DEVELOPMENT REVIEW BOARD
TRANSPORTATION DEVELOPMENT

DRB Project Number: 1002739

Anderson Heights

SUBJECT: Amended Preliminary Plat, Amended Site Plan for Subdivision, Sidewalk Deferral

Designed: DER	Drawn: DER	Checked: DMG	Sheet 1 of 5
Scale: 1" = 100'	Date: 11/20/17	Job: A17022

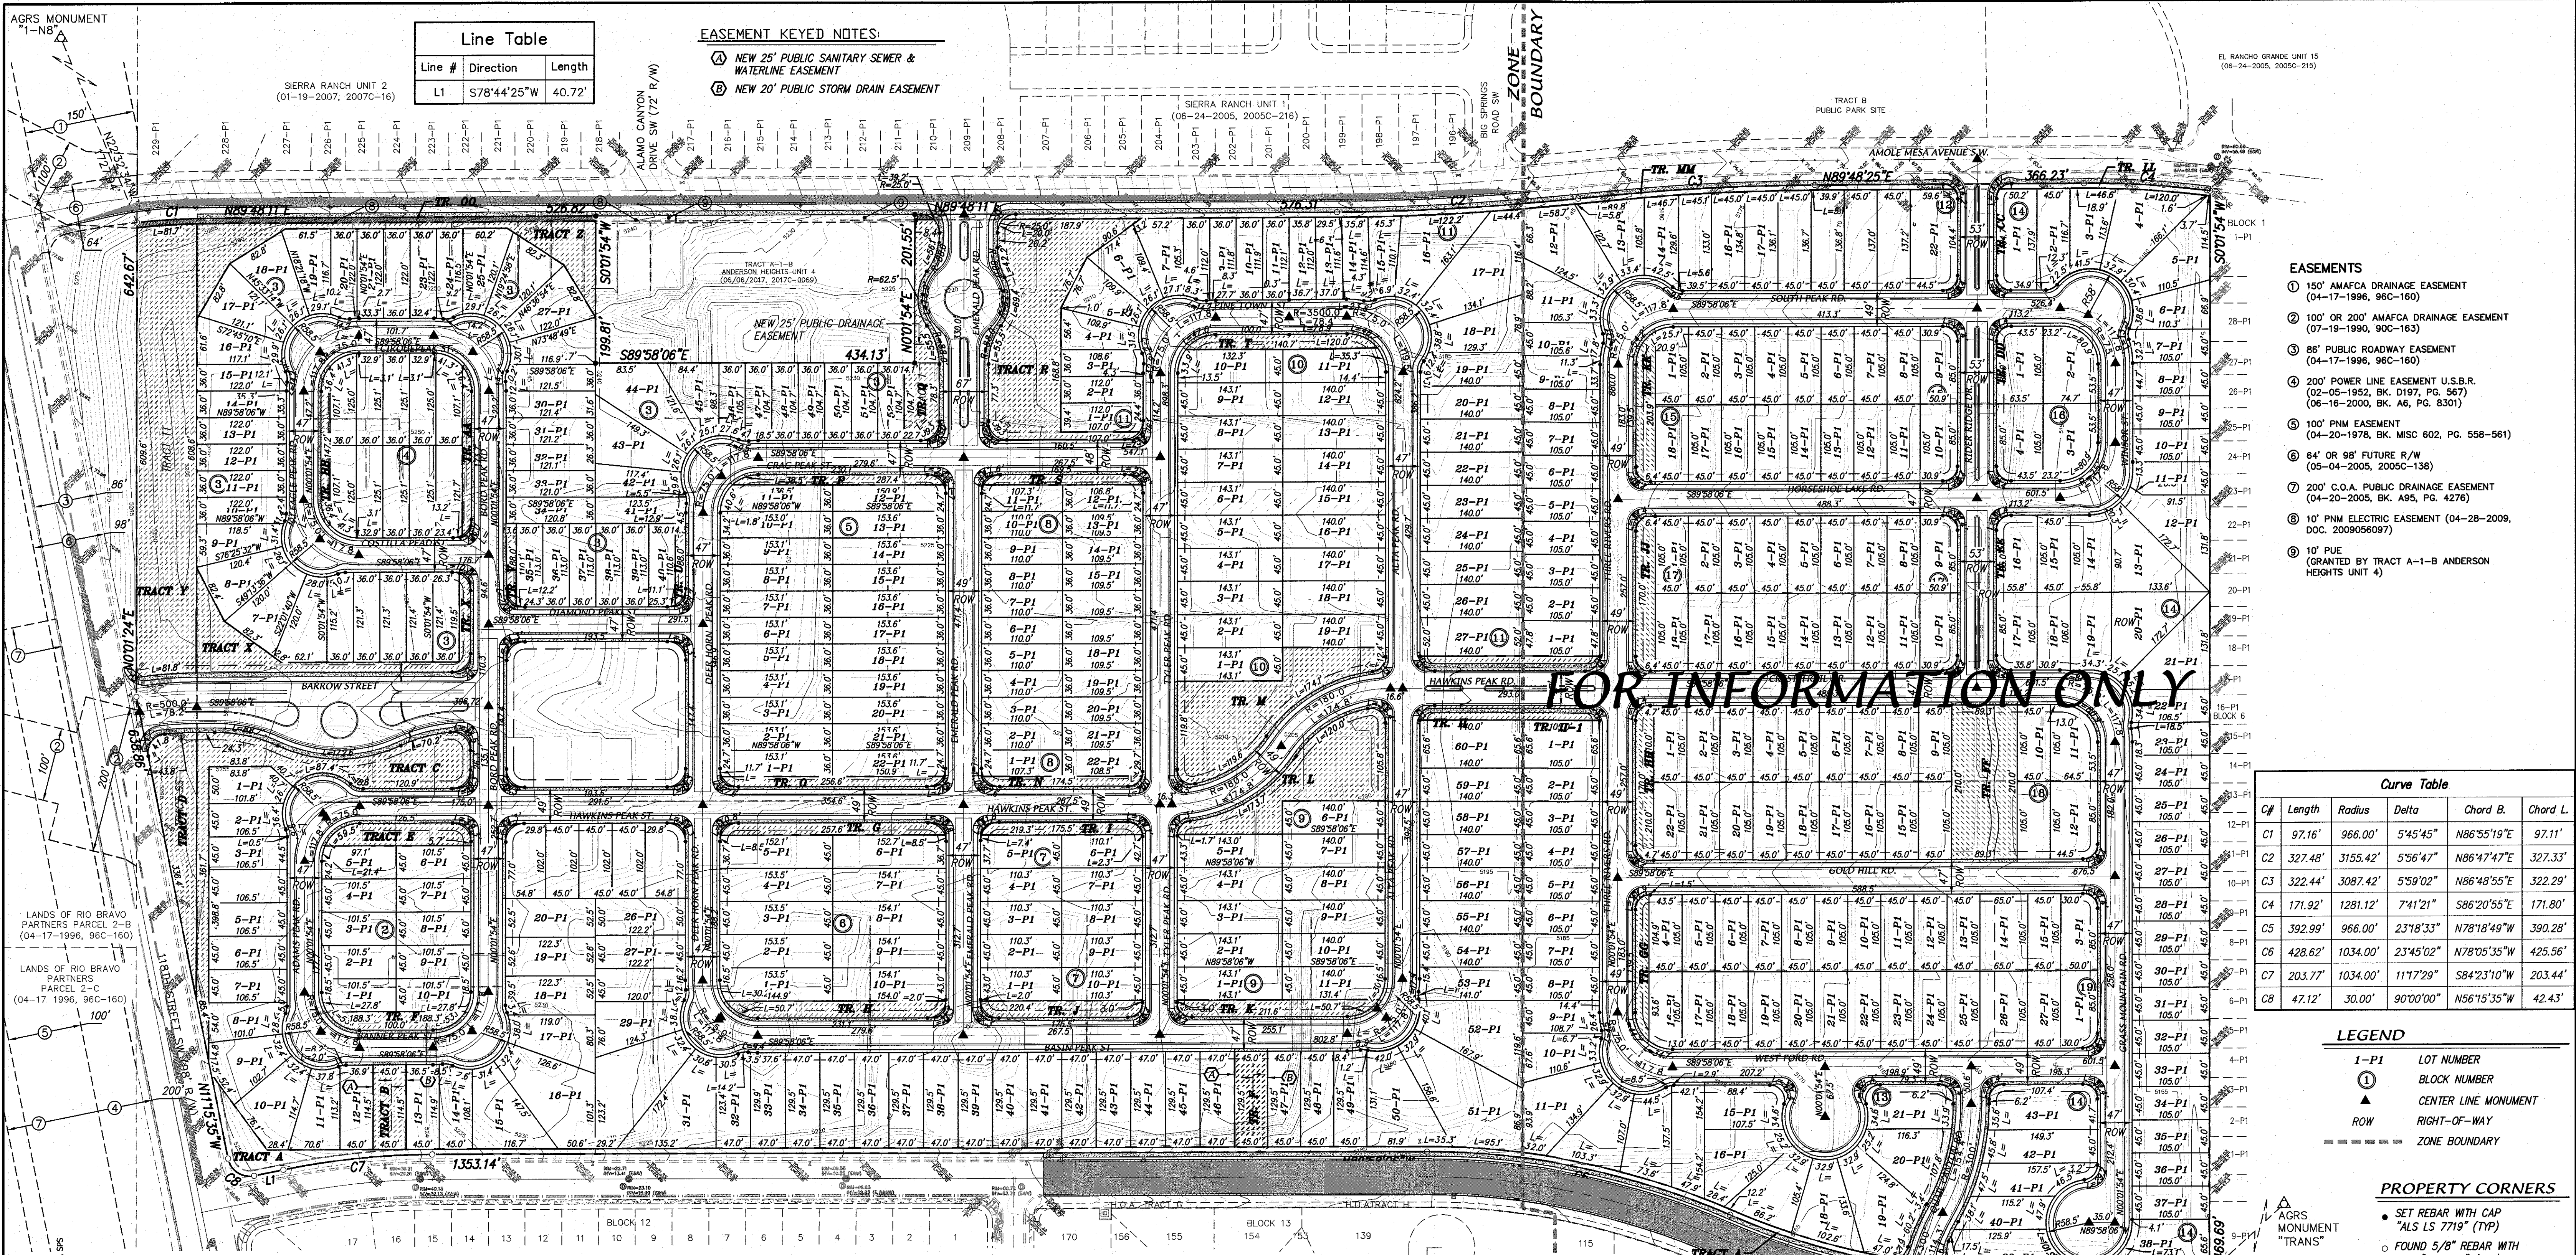
1. Tract II – add an access easement and change the width to 6' wide on IL.
2. Tract B – add an access easement and change the width to 6' wide on IL.
3. Crag Peak – 2 different ROW widths are listed.
4. Costilla Peak Way – Typo
5. Complete an overall check for street name consistency and typos.
